From: Mark Warwick
Sent: 14 May 2019 14:08
To: Amber Willard
Cc: Planning.Responses
Subject: Prior Notification Of Works To Tree(s) In A Conservation Area - BR/97/19/TC
Importance: High

Application ref: **BR/97/19/TC**

Location: The Shrubbery, 41 Upper Bognor Road, Bognor Regis, PO21 1HJ

Works proposed: Fell 1 No. lime tree and re-pollard to previous pollard points by 5-7 metres 2 No. lime trees within Bognor Road and Mead Lane Conservation area

ARUN DISTRICT COUNCIL BR/97/19/TC

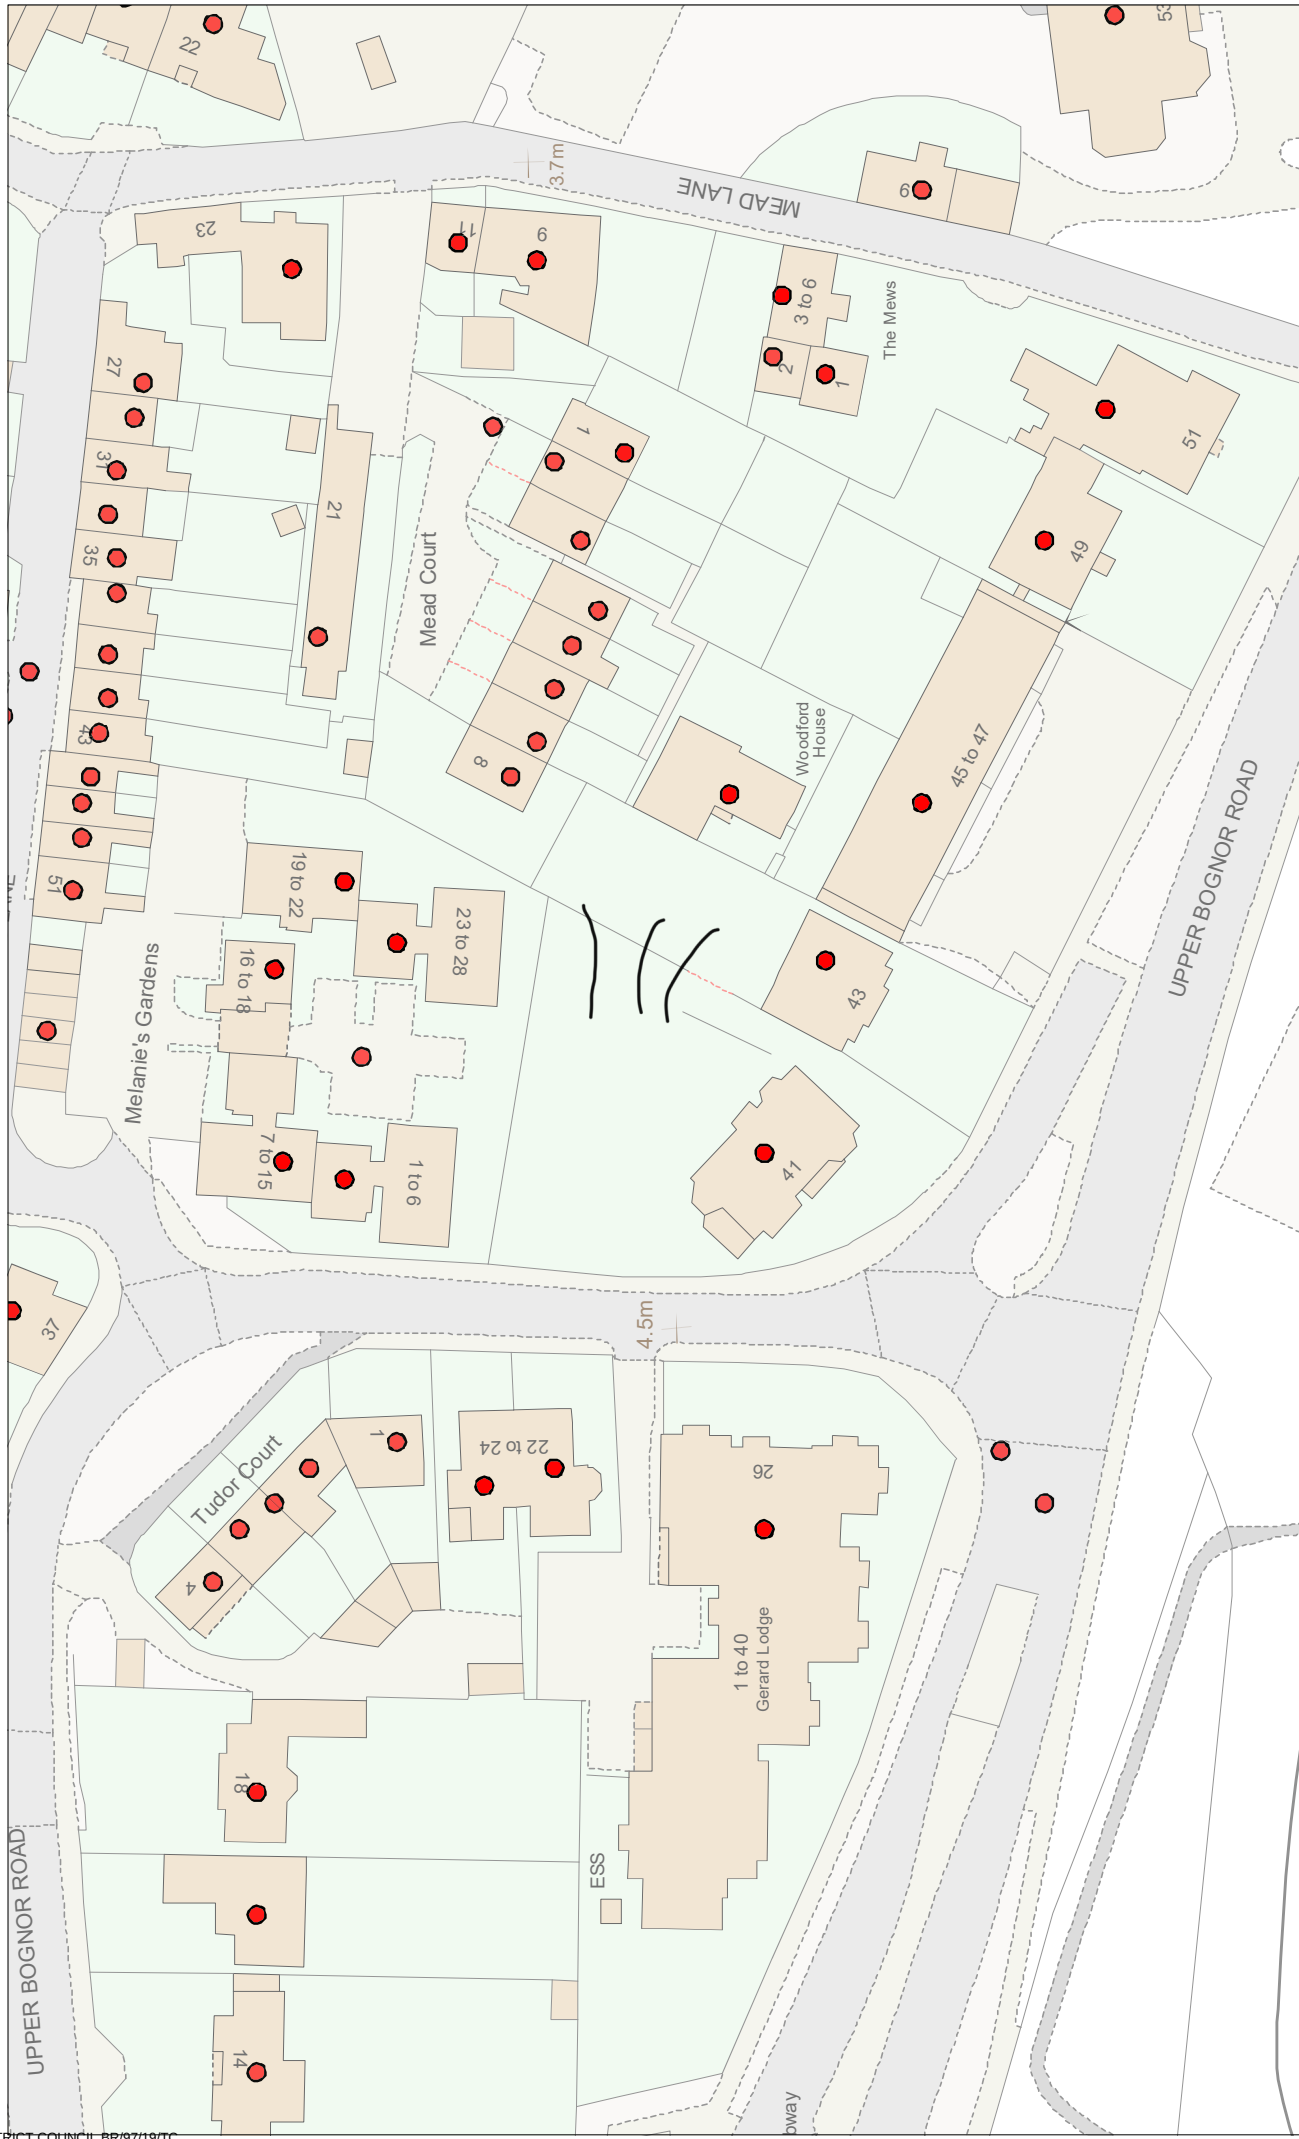
T1 and T2 - The work proposed has not been justified on arboricultural grounds and would be of visual detriment to the character of the surrounding area.

T3 - The work proposed has not been justified on arboricultural grounds and would be of visual detriment to the character of the surrounding area.

These are large trees with high canopy and of public amenity value - which in the absence of any evidenced significant structural defect and/or disease can be satisfactorily managed without recourse to felling and/or extensive crown reduction work at this time.

I recommend the making of a Tree Preservation Order to preserve these tree's contribution to the surrounding area. TEMPO forms and a GIS plan for this purpose can be found at the following location:
